From: Andrew Robley
Sent: 27 January 2017 18:05
To: Mark Peacock
Subject: FW: Northaw; The Oshwal Centre, Coopers lane Road; 16/1600LB

From: Andrew Robley
Sent: 27 January 2017 17:06
To: Mark Peacock <m.peacock@welhat.gov.uk>
Subject: Northaw; The Oshwal Centre, Coopers lane Road; 16/1600LB

This application is the same as that upon which I commented back on the 14/11/16 and although this application form refers only to window repairs, the heritage statement also includes stone repairs. I have therefore highlighted the parts that refer to the windows.

DRAWING TITLE WINDOWS 21-22-23	
DATE 15.05.2015	DRAWN BY DP
SCALE VARIOUS@A1, VARIOUS-1/2@A3	CHECKED BY LV
DRAWING NO. 6842-61-P0	REVISION

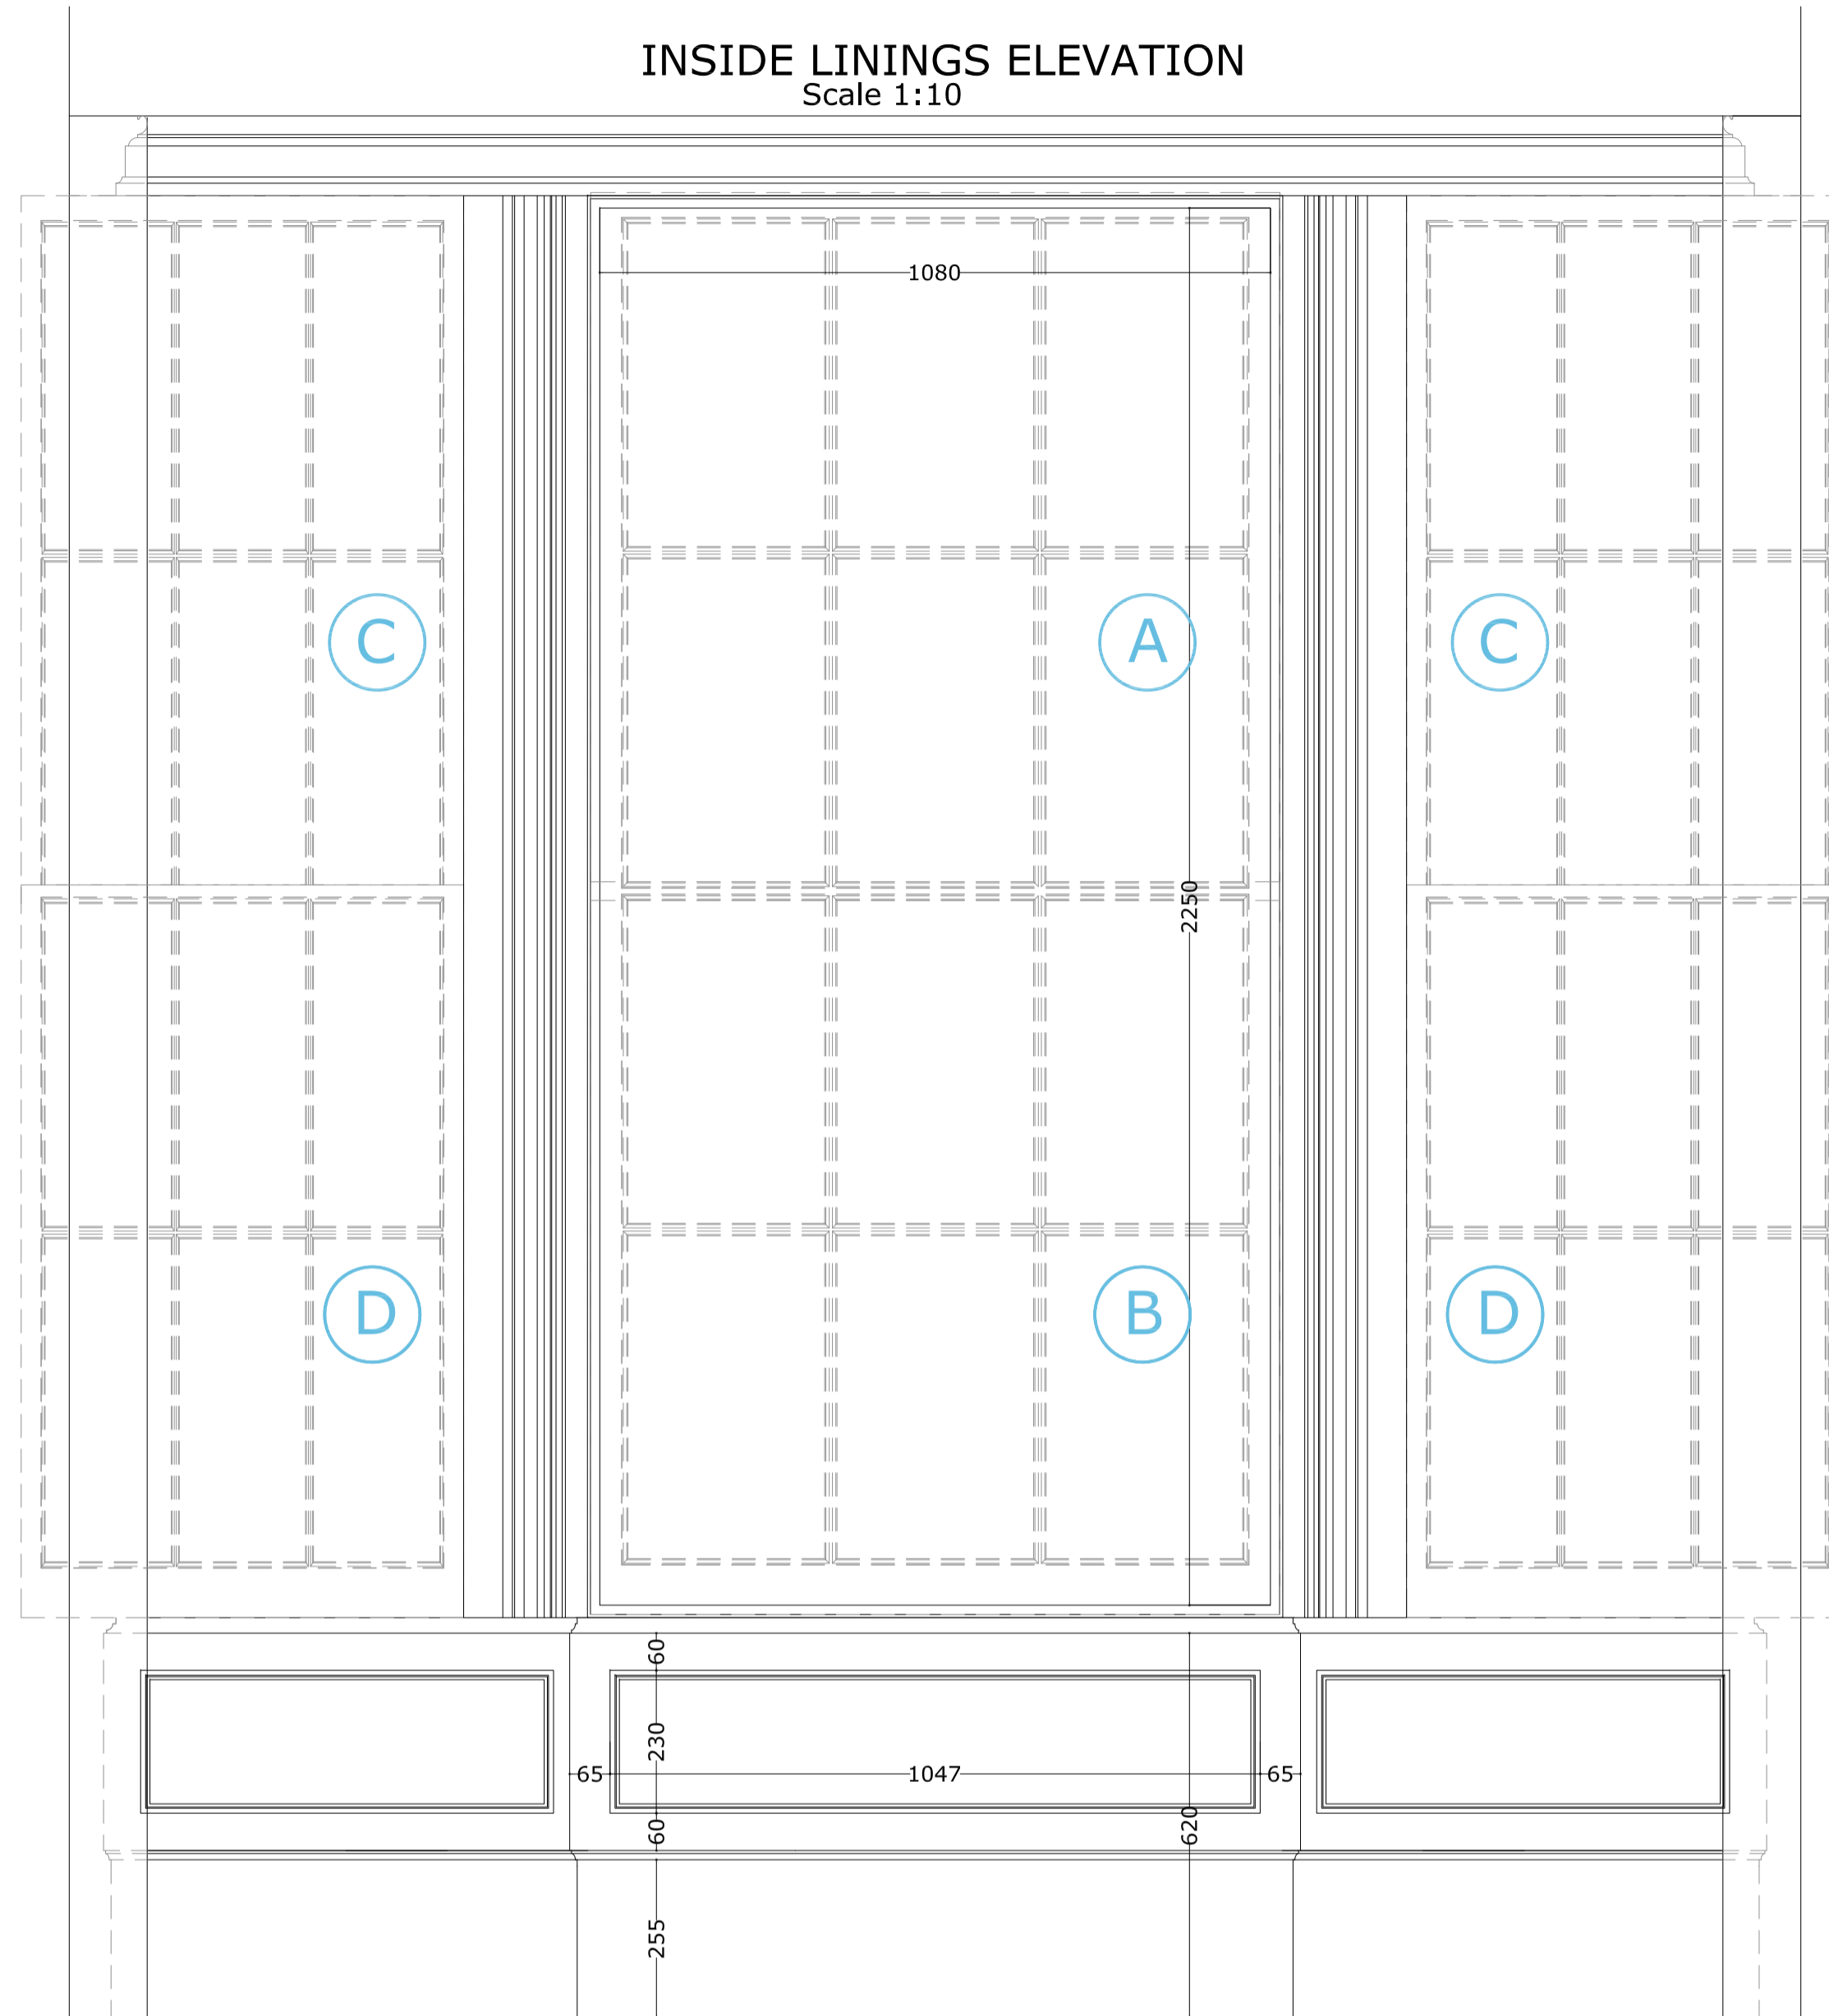
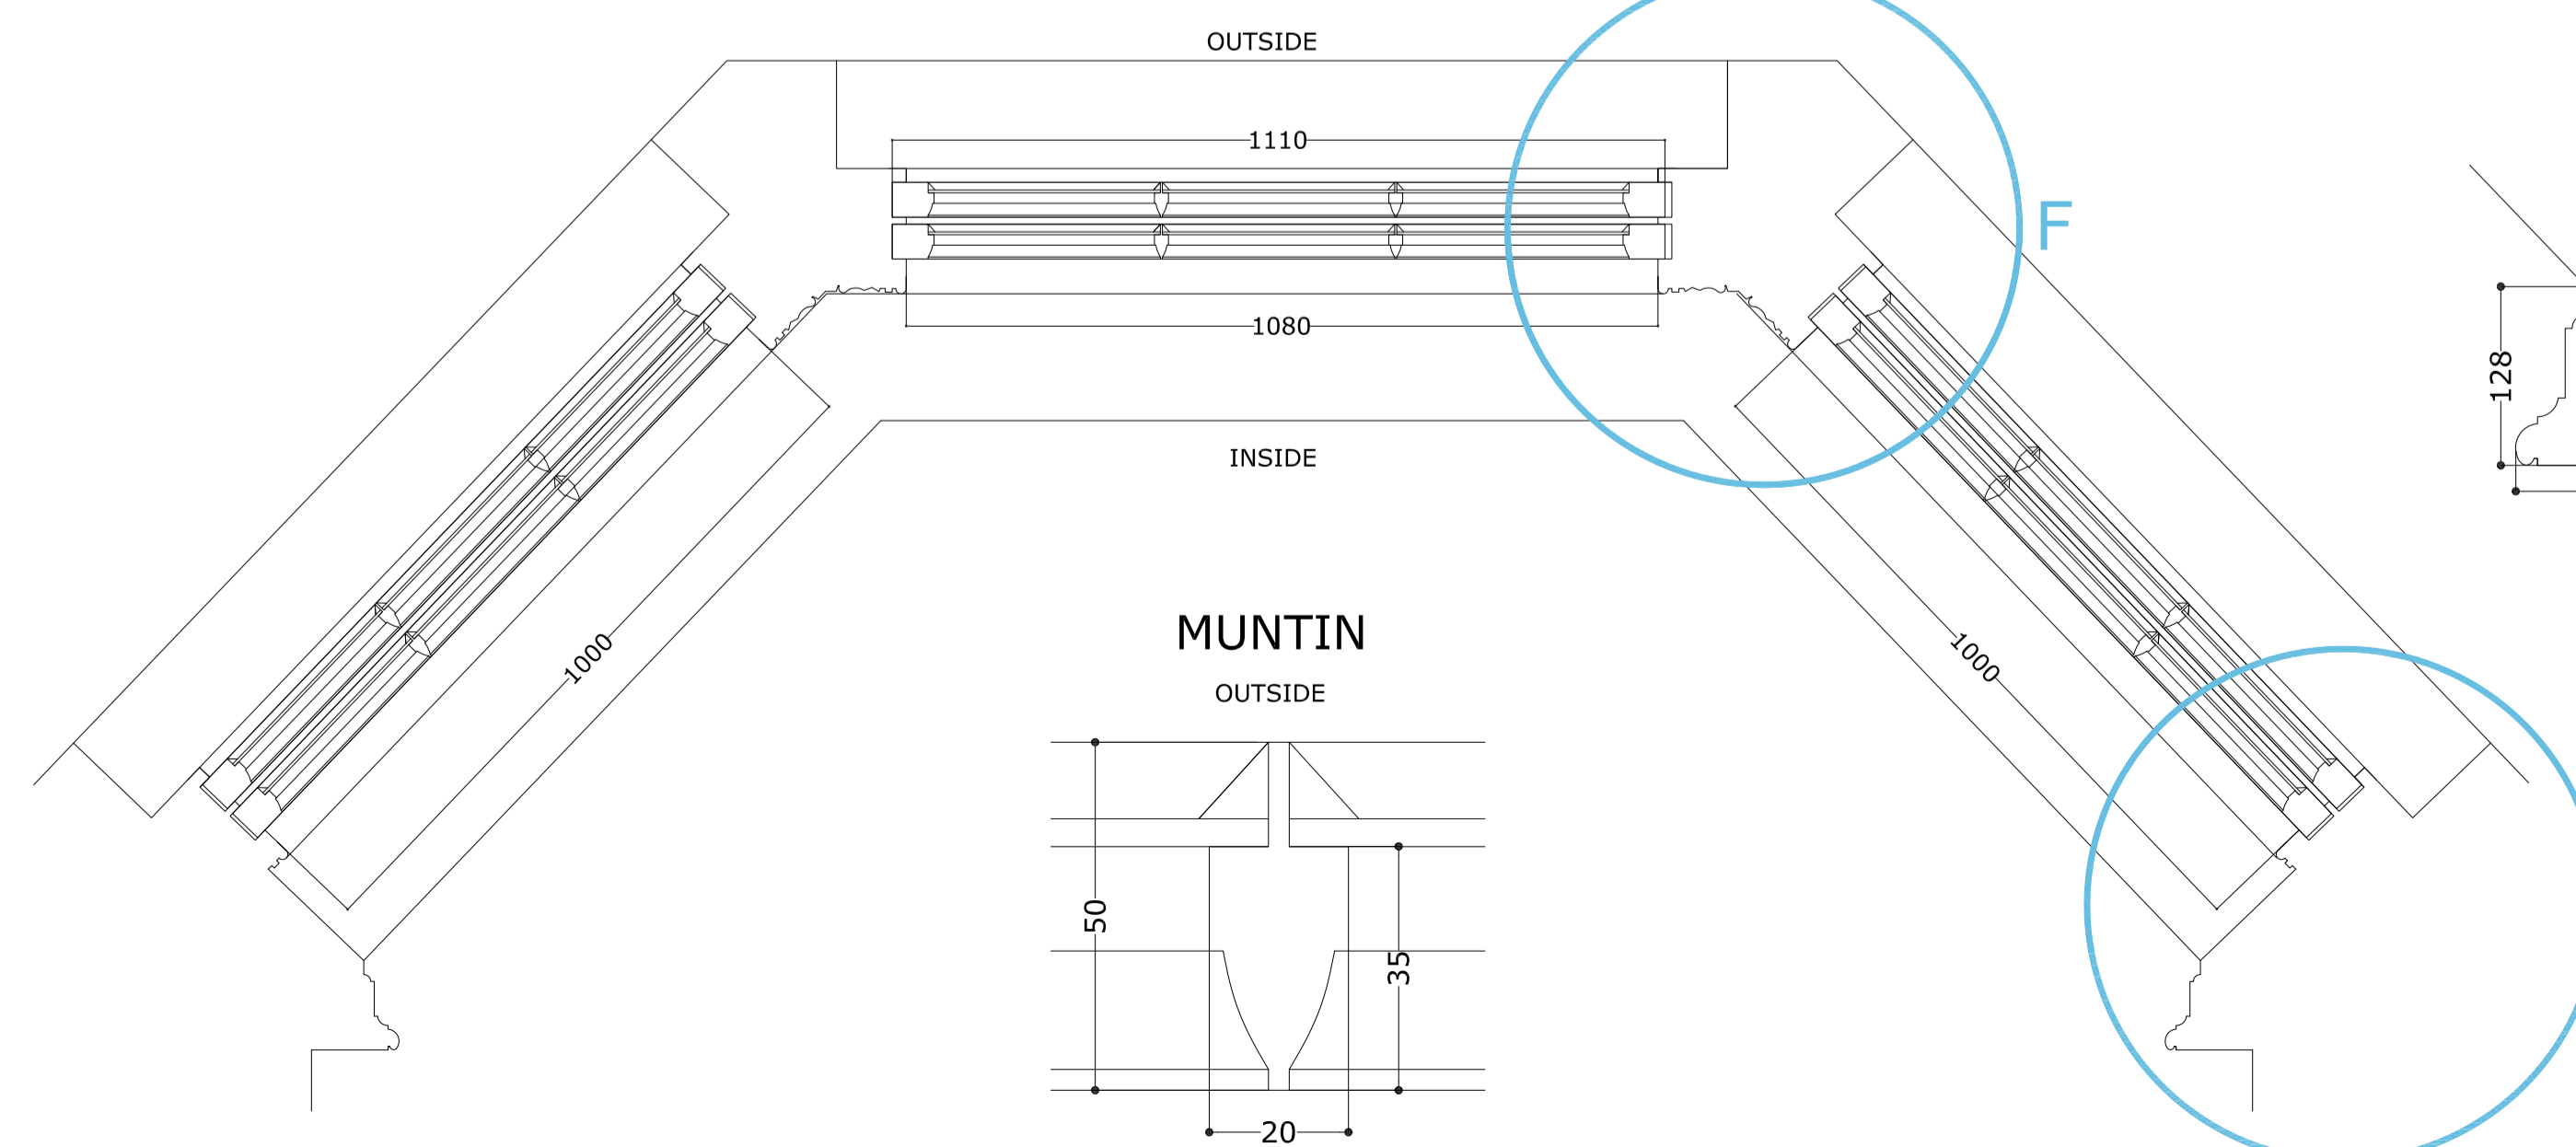
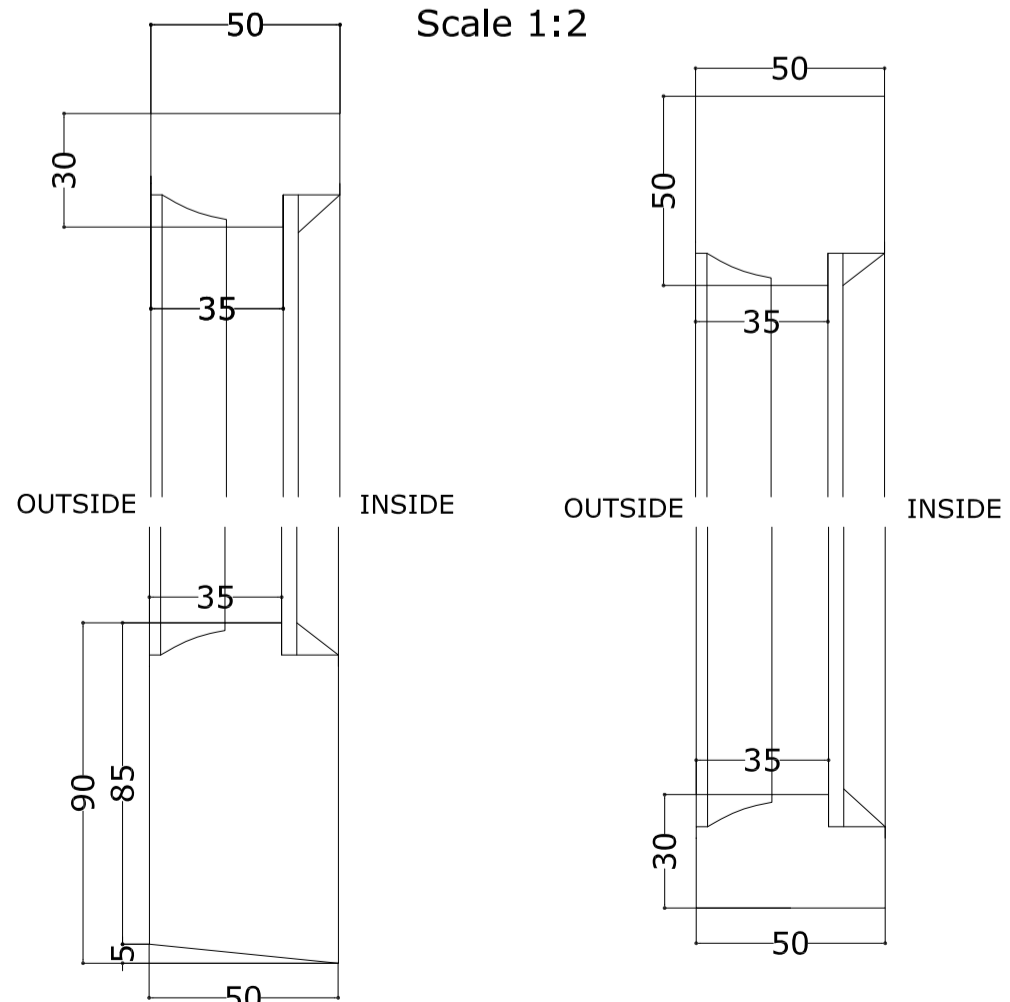
Following my site visit however, I can confirm that nearly all the windows are original and historic and contain some original or early cylinder or crown glass. There is some decay in the some of the windows largely in the usual locations of bottom rails and sills. They have not been painted externally for some time and the Heritage Statement refers to this. Many of them still have their original shutters. On my visit it seemed that most rooms were unoccupied.

The proposals are to replace all the windows with hybrid timber and aluminium double glazed units.

Windows: In a Regency House, the slim recessed Georgian sash windows are a particularly important architectural element. It is the period when glazing bars were at their finest and this is certainly the case here and the glazing bars are particularly fine. To replace these windows would irreversibly denude the building of much of its authenticity. The windows have been left unpainted for too long but all of the original ones are repairable. The Architect has ascertained that the decay is mostly due to dampness getting in through cracks in the render and/or lack of external paint protection and what he calls "humidity".

The report argues that although only some of the windows in their opinion need replacing, therefore all of them should be replaced to give a consistent “new” appearance. Whereas it is normal to expect an historic building to show its age and this can be part of its aesthetic appeal. The proposed window replacements are not even like for like in detail or in material and would not be acceptable in any case. The “glazing bars” are merely stick on applications to mimic the real thing.

The proposition that the existing windows would continue to decay once the dampness has been eradicated is incorrect. The timber used in windows of this period was slow grown Baltic Pine and is very durable as is evident from the number of them that still survive in buildings of early and mid-Georgian period as well as these late Georgian examples. If the dampness is dealt with the agents of decay such as dry or wet rot would not survive and the windows would not decay but if dampness is not dealt with, they will decay but then so would new timber windows –at a faster rate.

There is genuine concern that the windows are not energy efficient. However, there are ways in which this can be addressed to some extent and these are dealt with in the most recent Historic England advice document on the subject “Traditional Windows- their care repair and upgrading”. Some of the interventions can be as simple as closing the shutters when the room is not in use but here may be some cases where secondary glazing could be used..

The works should be reconsidered: A survey by a conservation accredited Architect or Surveyor should be a pre-requisite for works of this extent. The aim should be to retain all of the historic windows, repair and upgrade them if necessary in accordance with Historic England advice, using alternative, more conservative strategies for achieving better performance and greater longevity of paint systems. Original render (if any should be conserved) and any replacement render should
